Ribble Valley Borough Council
Council Offices
Church Walk,
Clitheroe
Lancashire
BB7 2RA

Phone: 0300 123 6780
Email: developeras@lancashire.gov.uk
Your ref: 3/2025/0981
Our ref: 3/2025/0981/HDC/KW
Date: 22 January 2026

Location: Former White Bull Hotel 257 Preston Road Longridge PR3 3BJ
Proposal: Conversion of a Former Public House to provide 3.no Dwellings to include the creation of new access points, landscaping, demolition of single storey rear extensions and erection of new single storey rear extension and window/door alterations and additions.
Grid Ref: 360020 435294

The Local Highway Authority (LHA) are in receipt of an application for the proposed conversion of a former public house to provide 3 dwellings including the creation of new access points, landscaping, demolition of single-storey rear extensions and erection of new single storey rear extension and window/door alterations and additions at the former White Bull Hotel, 257 Preston Road, Longridge.

Drawing Title
Proposed Site Plan and Landscaping Plan.

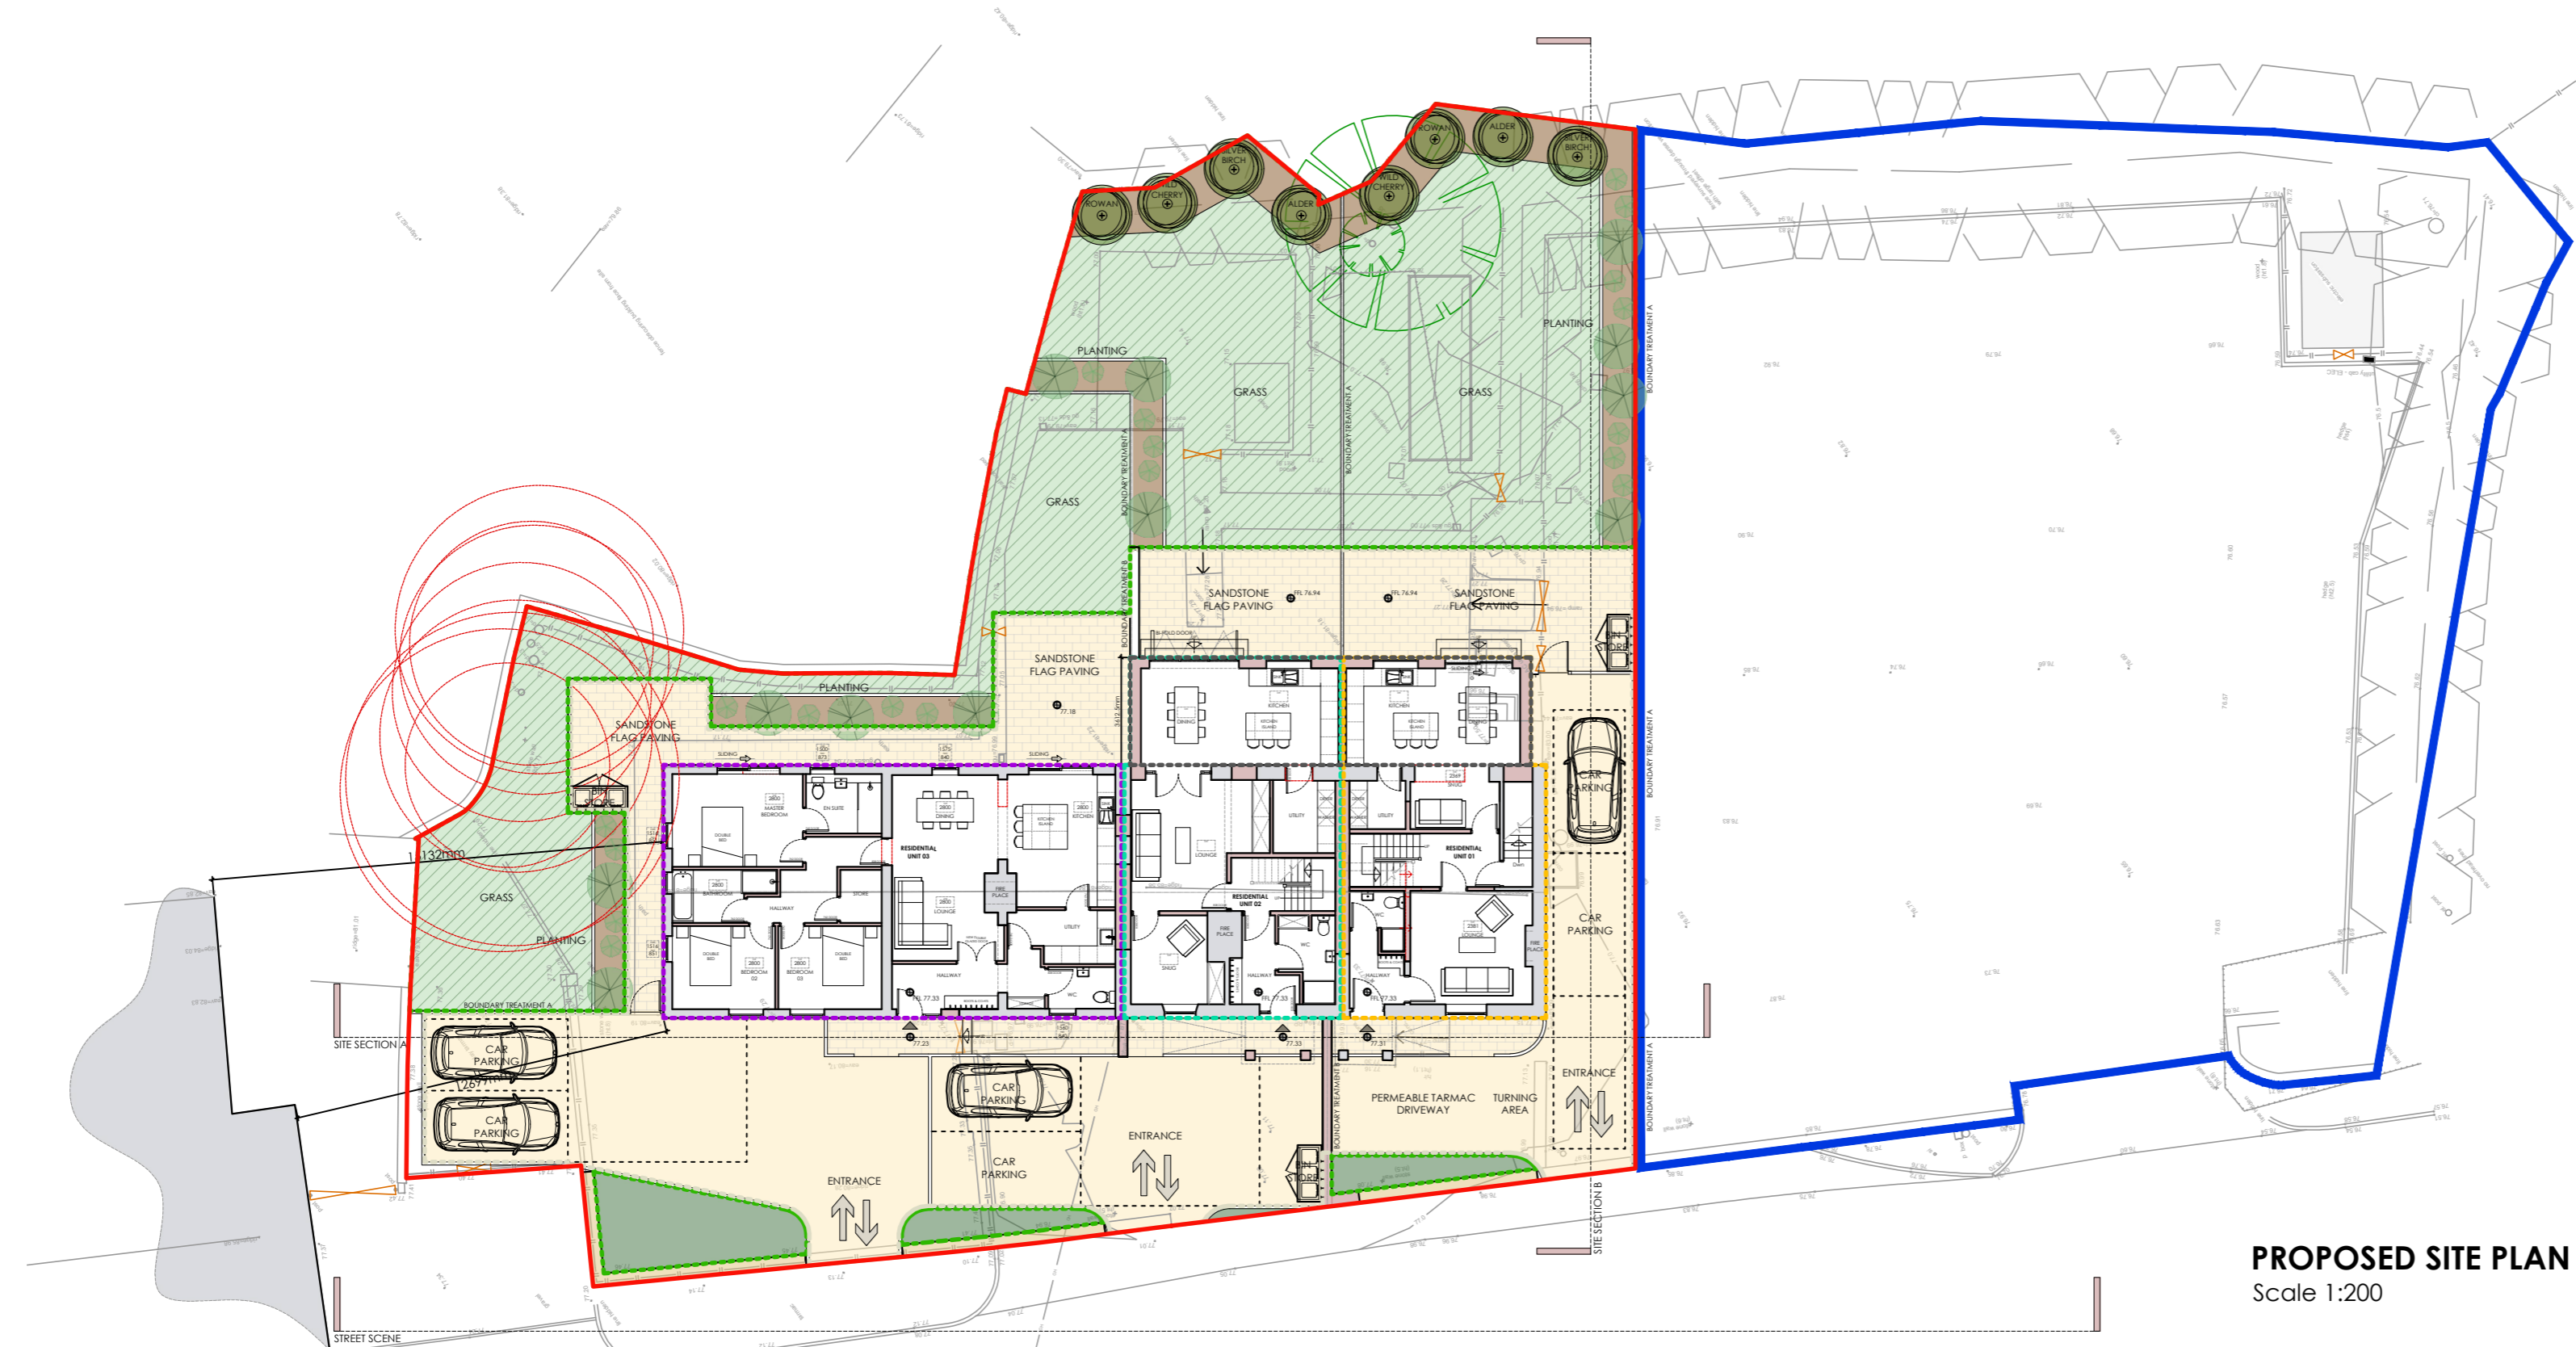
The proposal includes 3 new shared vehicle and pedestrian access points onto Preston Road, with each dwelling having its own access to a parking area. Residential access points must measure at least 3.2m wide to support vehicle and pedestrian movement.

As the car parking areas are accessed from a classified road, the LHA expect that turning provisions are provided internally to allow ingress and egress in forward gear creating safe and suitable access points. Residential Units 3 and 2 provided acceptable turning provisions. However, there are concerns that the constrained nature of the parking provision for Residential Unit 1 will result in parking within the turning area, rather than the suggested parking arrangements shown on the plan provided, ultimately resulting in reversing onto and from a classified road, which raises highway safety concerns. While the plan demonstrates that parking can take place its unlikely to take place in this manner in this practice, and as such, parking side by side would be more beneficial and provide a more practical turning area.

The LHA would request that visibility splays be provided at each access point. A 7 day Automatic Traffic Count was undertaken in 2024 to assess speeds along Preston Road. The observed 85th percentile speeds were recorded at 37.2mph northbound and 39.1mph southbound, which require splays of 2.4m by 56m northbound and 61m southbound. The visibility splay should be wholly within the land which the applicant controls and/or the adopted highway and nothing shall be erected, retained, planted and / or allowed to grow at or above a height of 0.9 metres above the nearside carriageway level which would obstruct the visibility splay of the proposed access.

There are particular concerns regarding the visibility of the access to Residential Unit 1 because of the close proximity to the proposed boundary treatment A, a 1.8m fenceline, which is proposed along the boundary of Residential Unit 1 and the existing Car park as currently there is no footway provisions, which maybe be able to act as a protective boundary for visibility, the current proposal would result in the site access leading directly to the carriageway and as such visibility splays would need to be positioned further back.

Due to the intensification of pedestrian movement linked with the proposed residential development of the site, the LHA expects that a 2m footway is provided across the frontage of the entire site, including the area within the blue edge. Currently there is limited pedestrian facilities fronting the site. Preston Road is a classified road with large vehicle movement, and as such, segregated provisions will create a safer option for pedestrians.

As footway provisions on the right end to the south of the site and cannot be tied into existing provisions to the north due to the positioning of neighbouring properties and limited carriageway widths to accommodate a continuous footway, the LHA will require an pedestrian crossing and refuse island to be provided linking the new footway to the existing provisions on the opposite side of the road. The footway and crossing provisions on both sides of the road shall be in line with inclusive mobile guidance and be supported by tactile paving. The footway provisions and crossing point will also provide safe, segregated pedestrian provisions to bus stops situated along Preston Road.

Due to the positioning of the residential access points, the refuse island and crossing points will need to be positioned fronting the existing car park so as not to conflict with turning into and out of the residential accesses.

Residential Units 2 and 3 have acceptable off street parking provisions with associated turning areas. While Unit 1 does provide acceptable off street parking provisions, the arrangements should be improved to provide more practical spaces, particularly given that there is adequate space within the applicant's ownership to provide this.

The proposed hard surfacing should be permeable to allow for natural drainage and surface water from the approved accesses shall be collected within the site and drained to a suitable internal outfall to prevent the discharge of water onto the adopted highway.

To ensure the development provides safe and suitable access for all users, further detailed information and revised plans are required. This includes amended parking and turning arrangements for Unit 1, full visibility splay drawings, proposals for a 2m footway and associated pedestrian crossing facilities as part of the required off-site works to be delivered through a Section 278 Agreement.
